PLANNING BOARD REPORT PORTLAND, MAINE

Twelve-Unit Condominium Building
One Joy Place
Subdivision, Level III Site Plan
and Conditional Use Inclusionary Zoning

Project #2017-103 (Subdivision & Site Plan)
Project #2017-128 (Conditional Use Inclusionary Zoning)
CBL: 045 E049001

Submitted to: Portland Planning Board Public Hearing Date: September 26, 2017	Prepared by: Jean Fraser, Planner Date: September 22, 2017
--	---

BRICK DRIVEWAY APRON

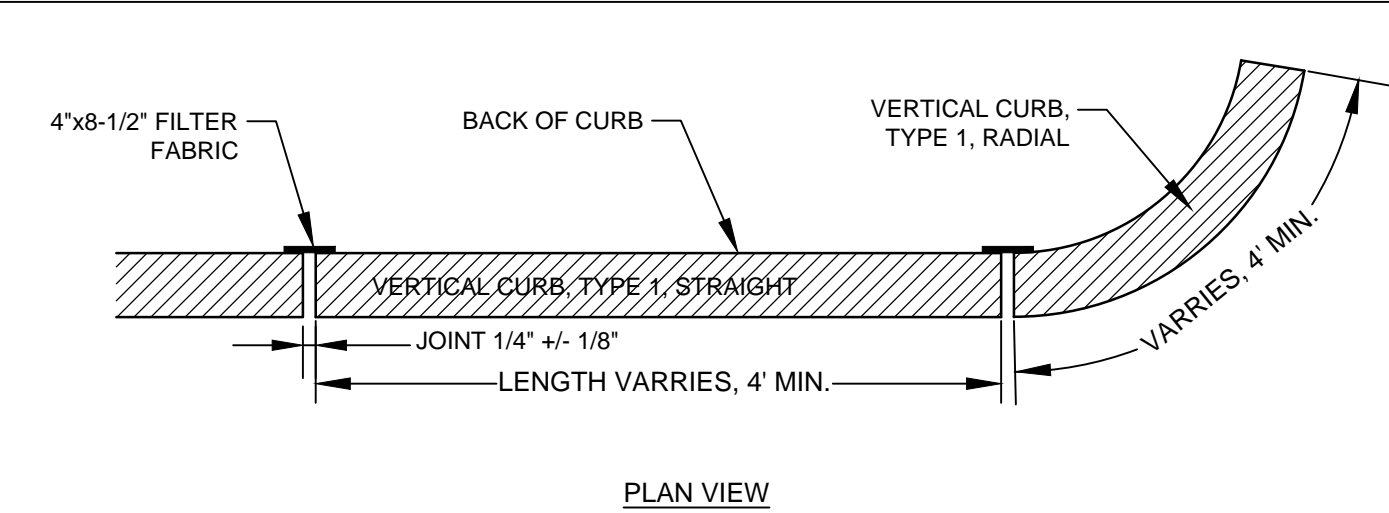
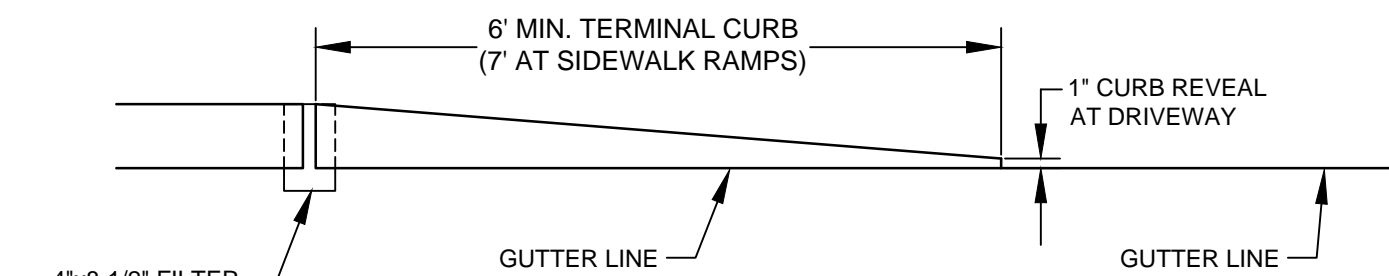
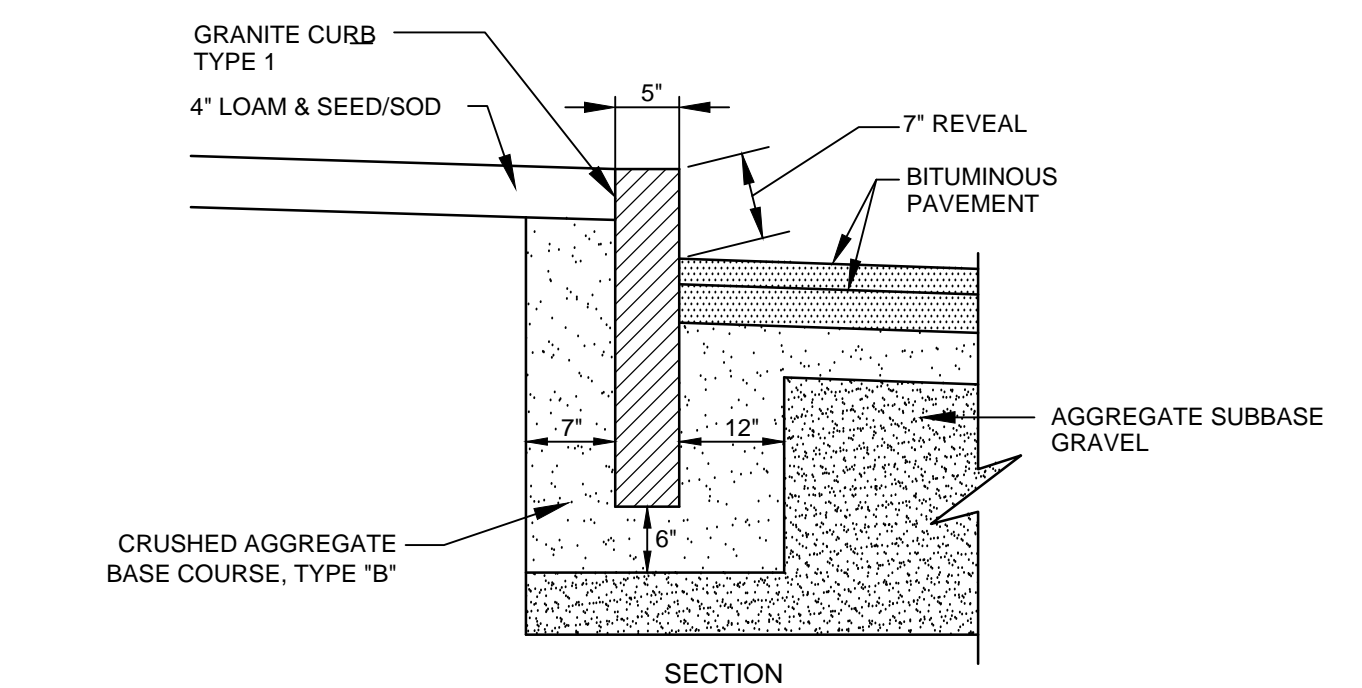
The applicant is proposing to reconstruct the apron and part of the sidewalk in brick paving; this is considered acceptable subject to adherence to the Technical Standards regarding materials/design and to addressing the Traffic engineer comments regarding the 2% cross slope requirement. These requirements are incorporated into suggested conditions of approval.

- viii. That the design of the apron and associated sidewalk shall meet Technical Standards and conform to the design detail provided in the final submissions (2% maximum cross-slope); and

SITE PLAN SCALE: 1" = 10'-0"

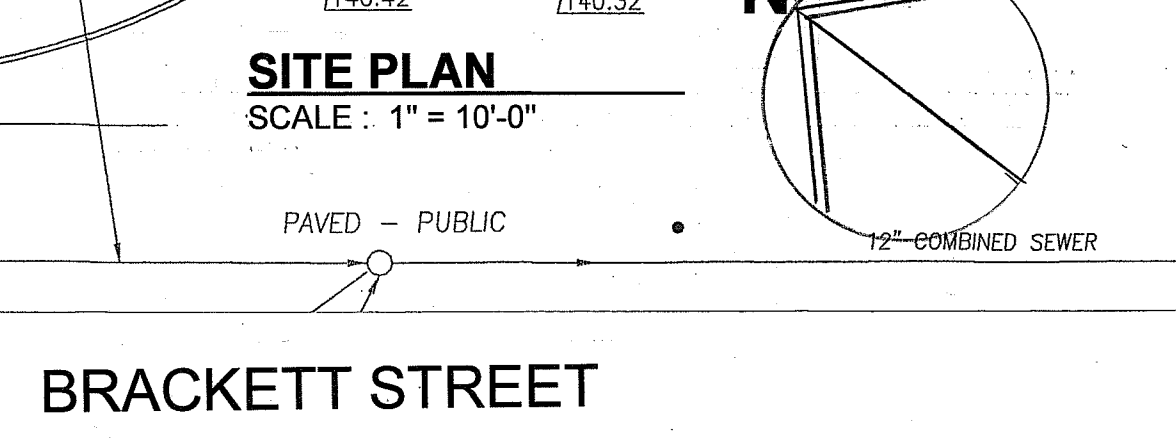
The proposed landscaping has been reviewed by the City Arborist and he recommends substituting a different species of tree for the proposed Amur Maple in the community open area (Attachment 4).

- v. That the Landscaping Plan shall be revised, for review and approval by the City Arborist and Planning Authority prior to the issuance of a building permit, to replace the Amur Maple with a species suggested by the City Arborist in his comments dated 9.21.2017; and
